Misleading Substation Information

Speech: DCO Planning Hearing – Substation Renderings

Morgan substation

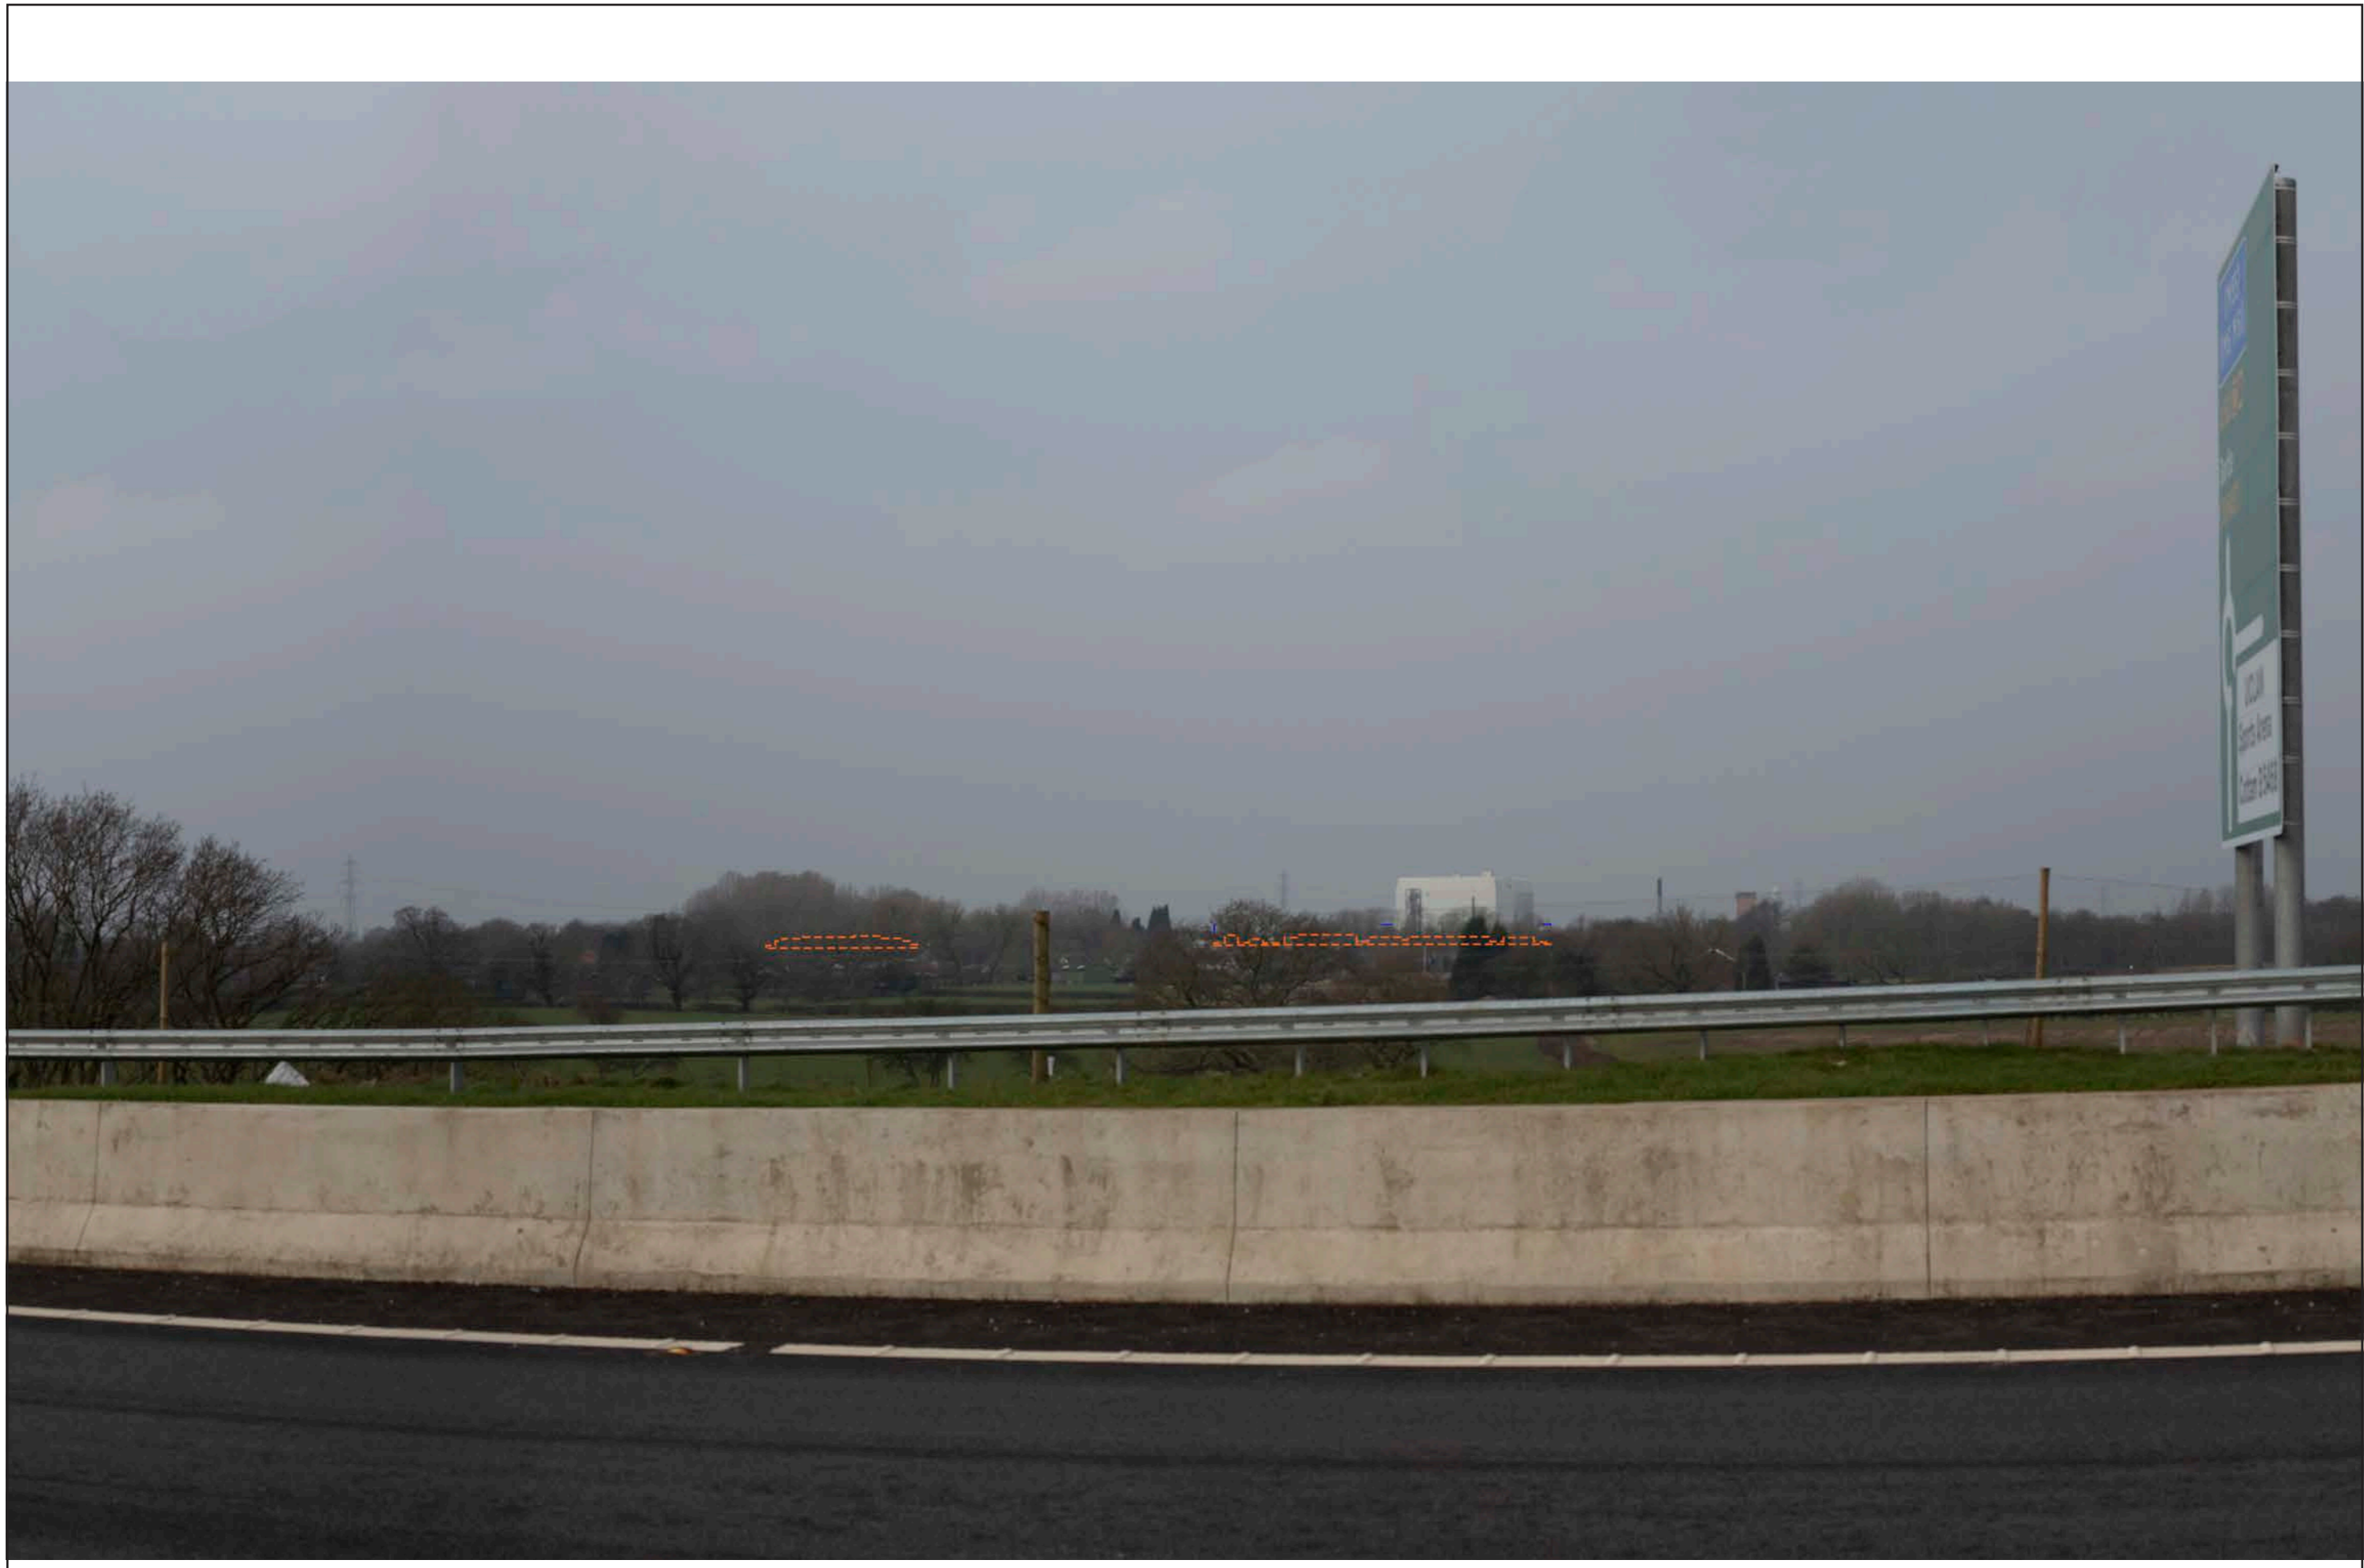
At ISH2 the inspectors also placed an action on the applicants, as the cross section figures in Doc ref S_D3_7 (PINS ref EN020028) provided at deadline 3 (July 25) appeared misleading. Having visited the sites and noting the slopes appeared to be a lot steeper in reality. On looking at this document the Figure 1 Topographic Context figure also causes concern. See a cut & paste from figure 1 below.

There appears to be quite a bit of cut & fill activity around the Morgan substation, but none around Morecambe. To the untrained eye this appears wrong. If the Rochdale envelope advice note nine is being used then surely there must be cut and fill activity required around Morecambe as well.
